NORFOLK BOREAS

Oulton Parish Council's response at Deadline 3

to the Applicant's "Clarification note-Cable Logistics Area" and to the Applicant's response to written questions at Deadline 2

Title:  
Onshore project area Scenario 1 & 2  
(Map 4 of 9)

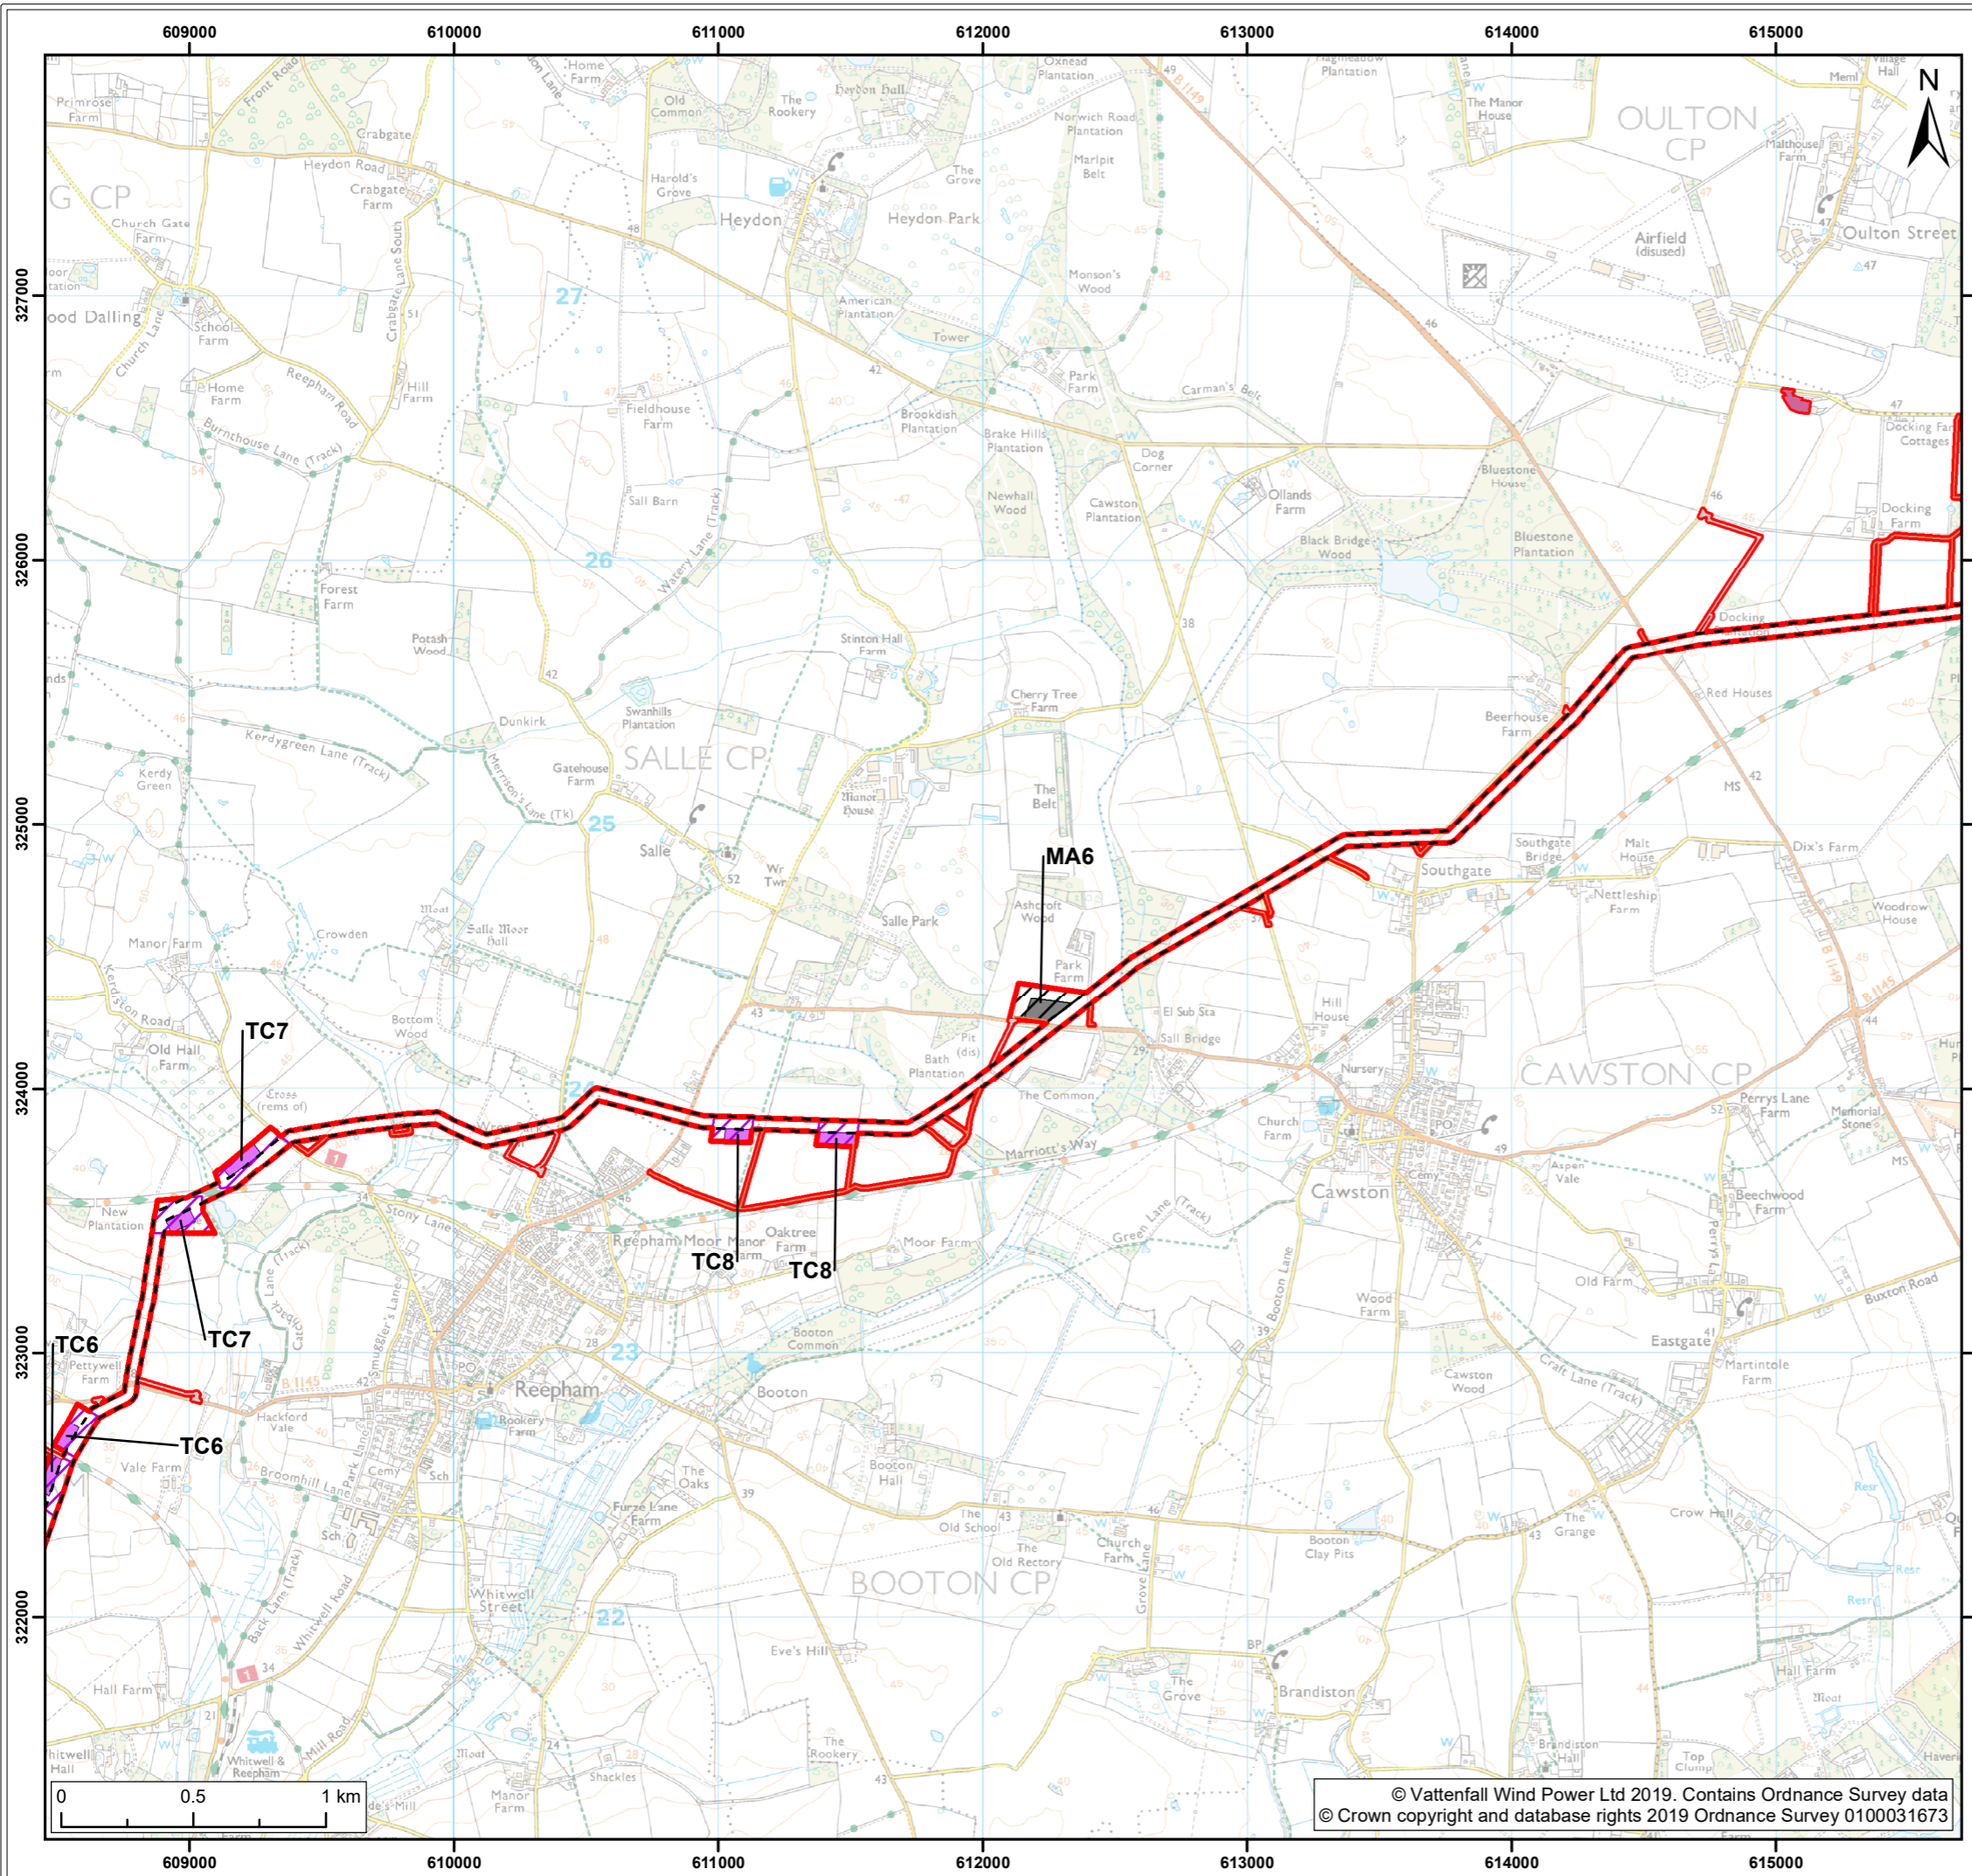
Oulton Parish Council (OPC) notes that the Applicants have reiterated that their preference is to deliver cable drums directly to the jointing pits, and have suggested that the Cable Logistics Area (CLA) would only be used for 'buffer' storage if needed. However, the CLA is in effect *the only storage facility for the entire project* during the cable pulling phase and it is clear that both cable drums and other "associated materials" will be distributed from there to other parts of the cable route. The 'just in time' nature of construction suggests that there will always be a rolling reserve of cable drums and associated materials in storage, ready for delivery in case of mishap to any part of the cable route.

The Applicant's Cable Logistics Area - just like Hornsea Three's Main Construction Compound, also in Oulton - is a convenient location for a *central distribution compound for the whole project*, and will be used as such.

In view of the above, and to avoid the creeping expansion of the function of the CLA over time, OPC seeks assurance that requirements will be secured in the DCO to stipulate that "associated materials" that might be stored at the CLA, during either Scenarios 1 or 2, *will never include* aggregate, soils or any general building materials.

It is noted that – for the first time – mention is made here above of a requirement for some localised road widening (passing places) on *the Heydon Rd section* of Link 68. OPC have not seen any plans indicating the precise location of these passing places. We have concerns as to whether this would impact the residents of Heydon Rd, and as to whether these modifications are to be temporary. It is also noted that, with the road modifications on the rest of LINK 68 ‘The Street’ for HOW3/Vanguard/Boreas, this further extends the impacts on local residents’ ability to use the local roads without coming upon HGVs, temporary road closures or diversions, or having to be escorted down 1 - 1.5km of road by pilot vehicles in a convoy.

Furthermore, we reiterate that for the first time there is mention of the creation of *further passing places* on a section of Link 68 - Heydon Road. OPC seeks assurances as to whether NCC Highways have agreed to this new development.
